**Consultation Response from KC,
Highways Development Management**

2025/92443 Huddersfield Open Market, Brook Street, Huddersfield, HD1 1DY

Date Responded: 29/12/2025

Refuse Vehicle Route.

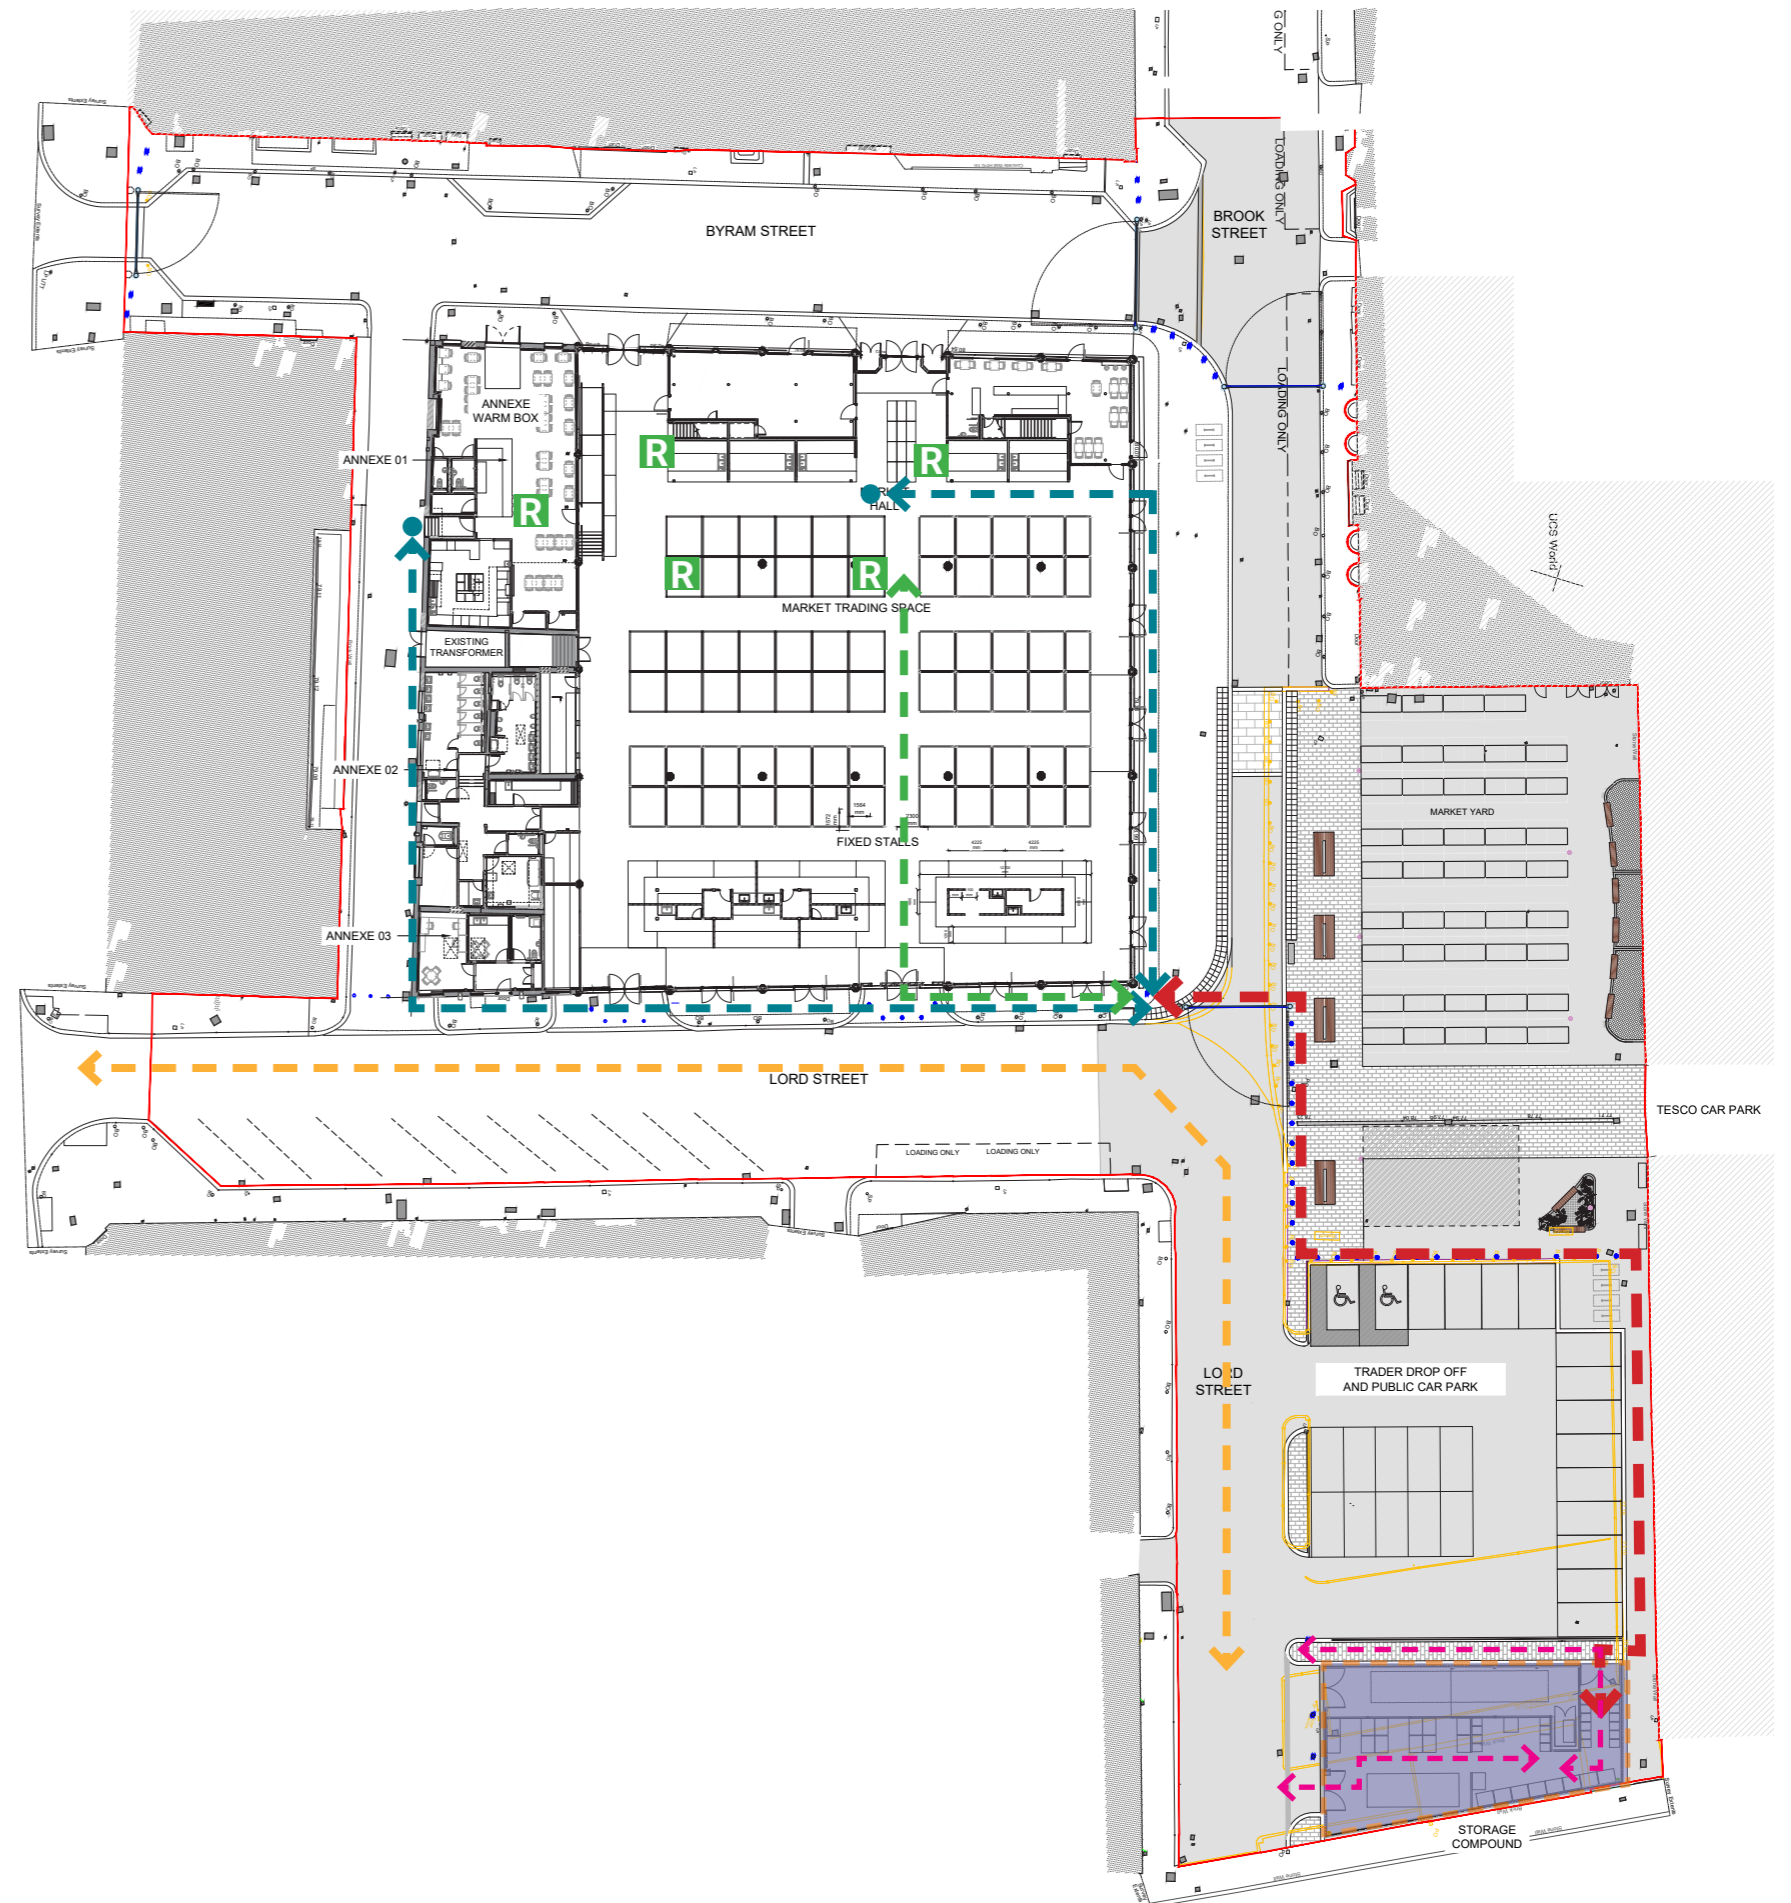
Swept path analysis drawings were submitted (Drawing Nos D110 to D115), covering an articulated lorry, a refuse vehicle, a private car, a fire tender, a panel van and a delivery vehicle. The swept paths were based on the original proposal layout with the smaller refuse area and the container pavilion. The design has since changed and because of this we would like to see the resubmission of drawing D111 for the refuse vehicle to clearly show that the new refuse storage point is safely accessible by an 11.85m refuse vehicle. This can be conditioned. The swept path analysis should keep reversing movements to a minimum for highway safety reasons.

Notwithstanding the details shown on the approved plan, no development shall take place until a scheme detailing arrangements and specification for vehicular access to the waste storage/collection area, consisting of a swept path analysis for an 11.85m refuse vehicle, has been submitted to and approved in writing by the Local Planning Authority.
